RWE Renewables UK Solar and Storage Limited

Planning Act 2008 – section 51 - Response to Advice following issue of acceptance decision

Application reference: EN010157

On 21 March 2025 the Planning Inspectorate (PINS) issued a decision to accept for examination a Development Consent Order Application (the DCO Application) made by RWE Solar and Storage UK Limited (the Applicant) in respect of the Peartree Hill Solar Farm (the Proposed Development).

28/08/2025 16:32

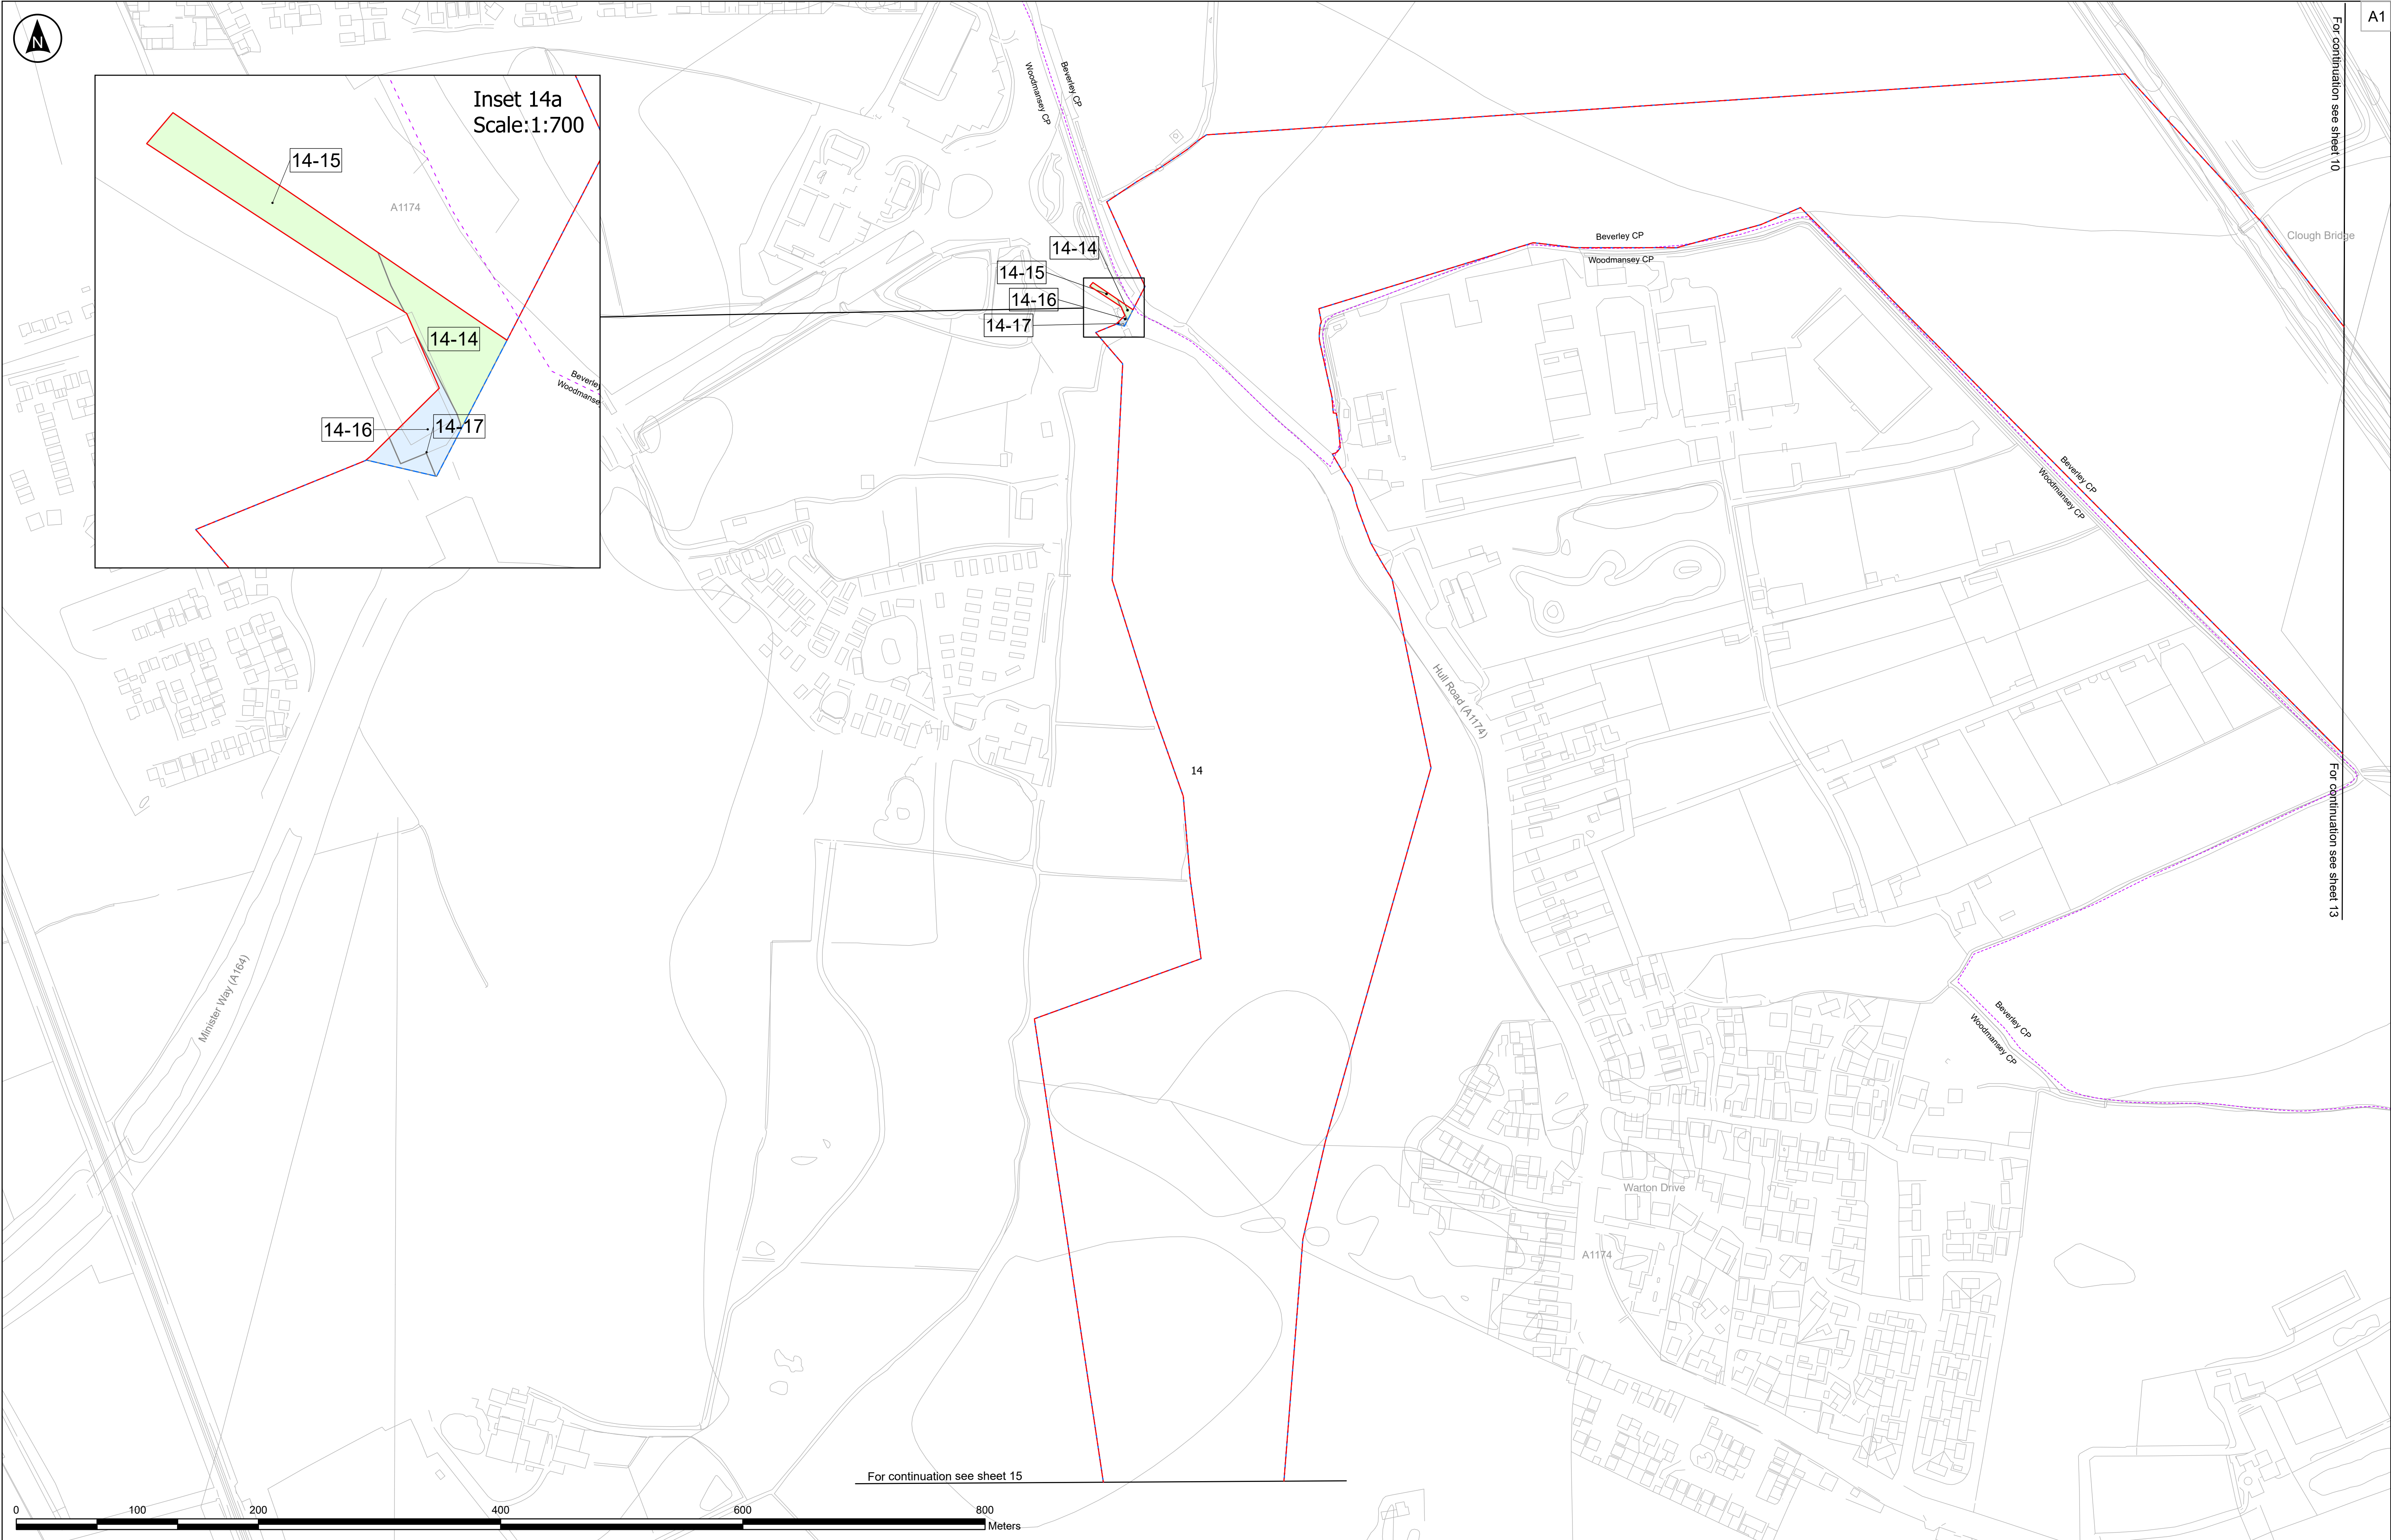
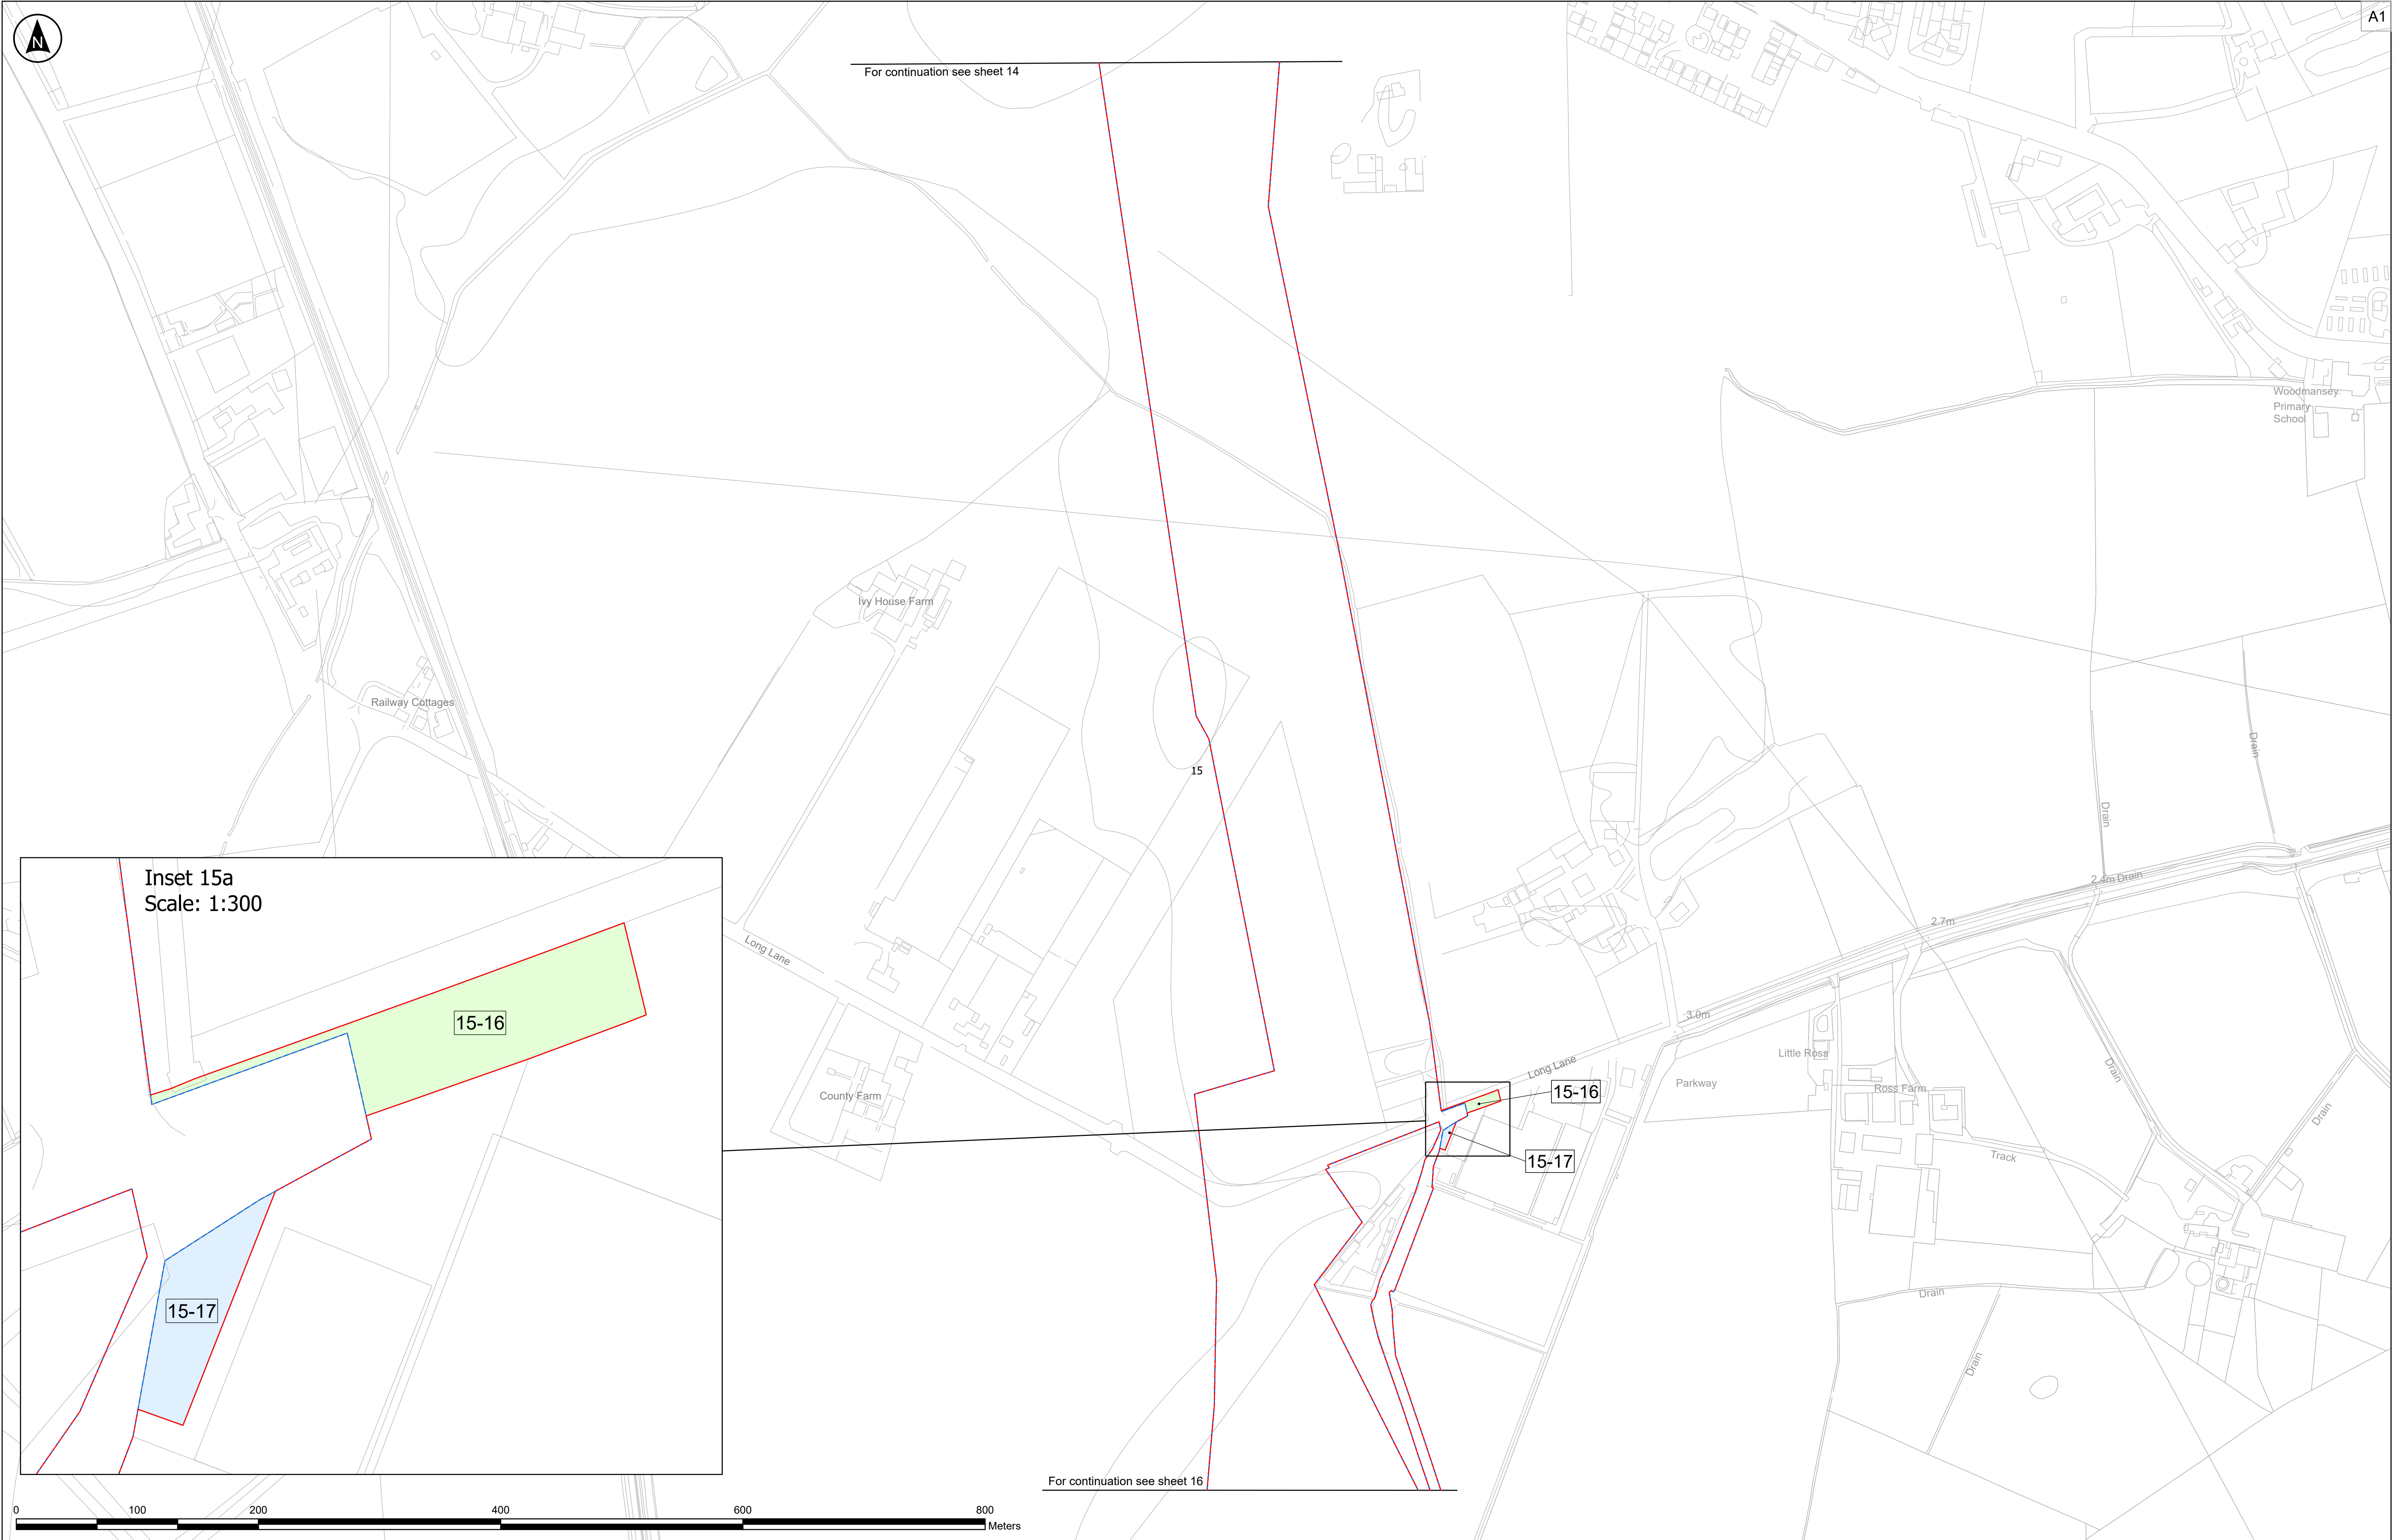
2. **Correction 2:** The Applicant also proposes to remove a section of private road (Carr Lane) that is no longer needed in connection with the Proposed Development following the relocation of the site access further west. This land will be removed from the Order Limits, resulting in a minor reduction in the scope of compulsory acquisition powers sought in respect of land. An image showing the land, identified as parcels 10-4, 10-5 and 10-6, to be removed from the Order Limits is set out below as **Figure 3**.

Figure 3 Extract of submitted Land Plans showing parcels 10-4, 10-5 and 10-6 now proposed to be removed
